KIRKLEES METROPOLITAN COUNCIL INVESTMENT & REGENERATION SERVICE

DELEGATED DECISION TO DETERMINE APPLICATIONS FOR CONSENT, AGREEMENT OR APPROVAL REQUIRED BY CONDITION

Reference No:	2023/44/90216/W
Site Address:	adj, 17, Hillhouse Lane, Fartown, Huddersfield, HD1 6EF
Description:	Discharge condition 15 (extract ventilation system) on previous permission 2019/93483 for erection of 4 A1/A3 ground floor units, 3 B1 offices and ancillary space, free standing ATM and car park
Recommending Officer:	John Holmes

DECISION – Details submitted for condition 15 approved

DATE : JAN 23	SCALE : NTS @ A1
JOB NO. : -	DRAWN BY : TS
DWG NO. : M001	REV : -01
STATUS :	COMMENTS

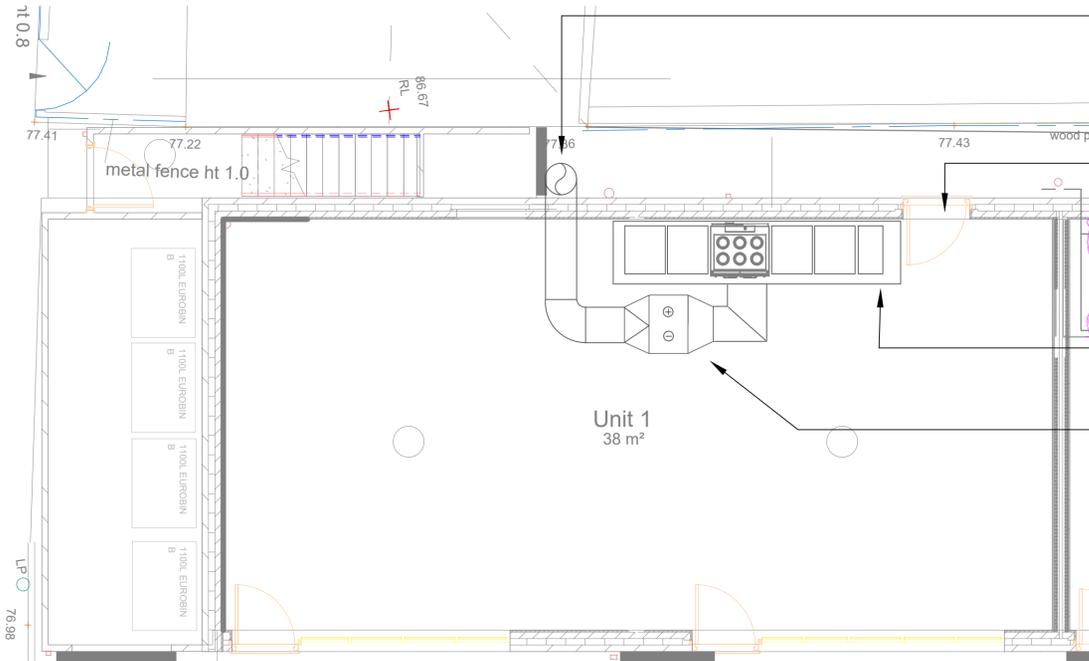
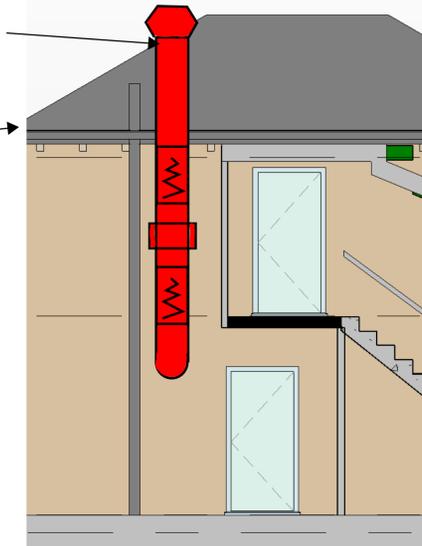
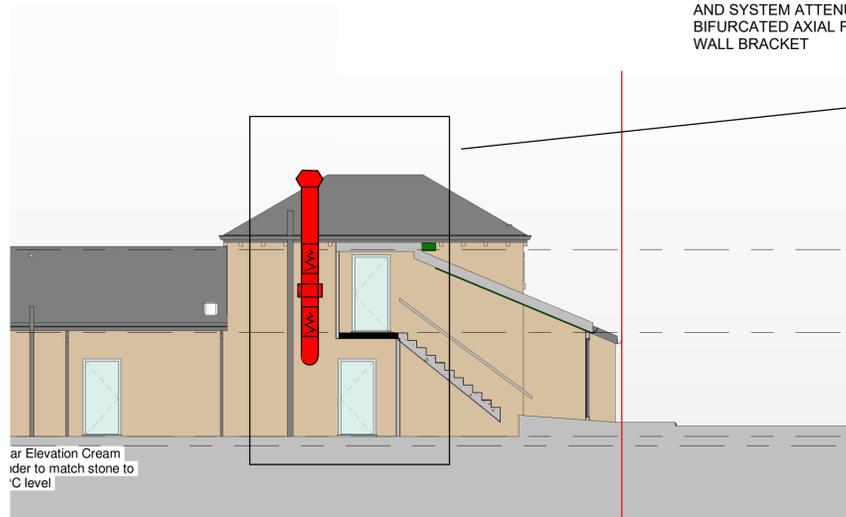
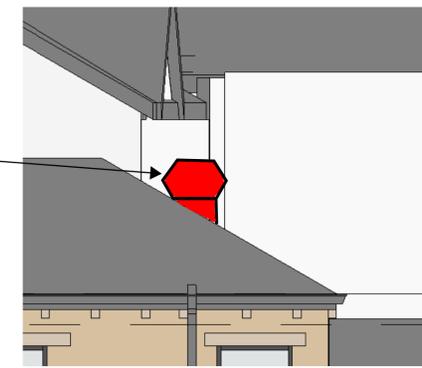
Drawing M001 Mechanical Services Kitchen Ventilation Layout. This details the means of extraction to serve unit no.1, including noise and filtration and elevational details of the external flue.

The Council's Environmental Health Team have been consulted, and stated that the submitted drawings, details and annotations describe in detail the proposed kitchen ventilation system. This system is set out in their response to consist of: kitchen canopy, pre-filters, electrostatic precipitator, bifurcated extract fan, outside noise attenuators and a high velocity roof cowl which is to terminate 1m above the apex of the roof. The Environmental Health Team advises they accept the scheme submitted and request the condition is not discharged until the system is installed and fully operational.

The submitted scheme sets out an extraction system in a less prominent part of the site, and which is considered to meet the requirements to ensure there is not significant levels of noise or odour as a result of the system, given the response of the Environmental Health Team. It is located between the rear of

the unit and the side wall of the closest dwelling on Hillhouse Lane. This would satisfy the reasons for imposing condition 15.

Given the ongoing requirement of the condition that the approved scheme shall be installed before the system is first brought into use and retained and maintained in accordance with the manufacturers' instructions thereafter, it is considered that the details submitted can be approved, notwithstanding the comments of the Environmental Health team seeking to reserve discharge of the condition until it is in place and operational.

It is recommended any approval advises the applicant of the requirement of the condition to have the approved scheme in place before the use commences.
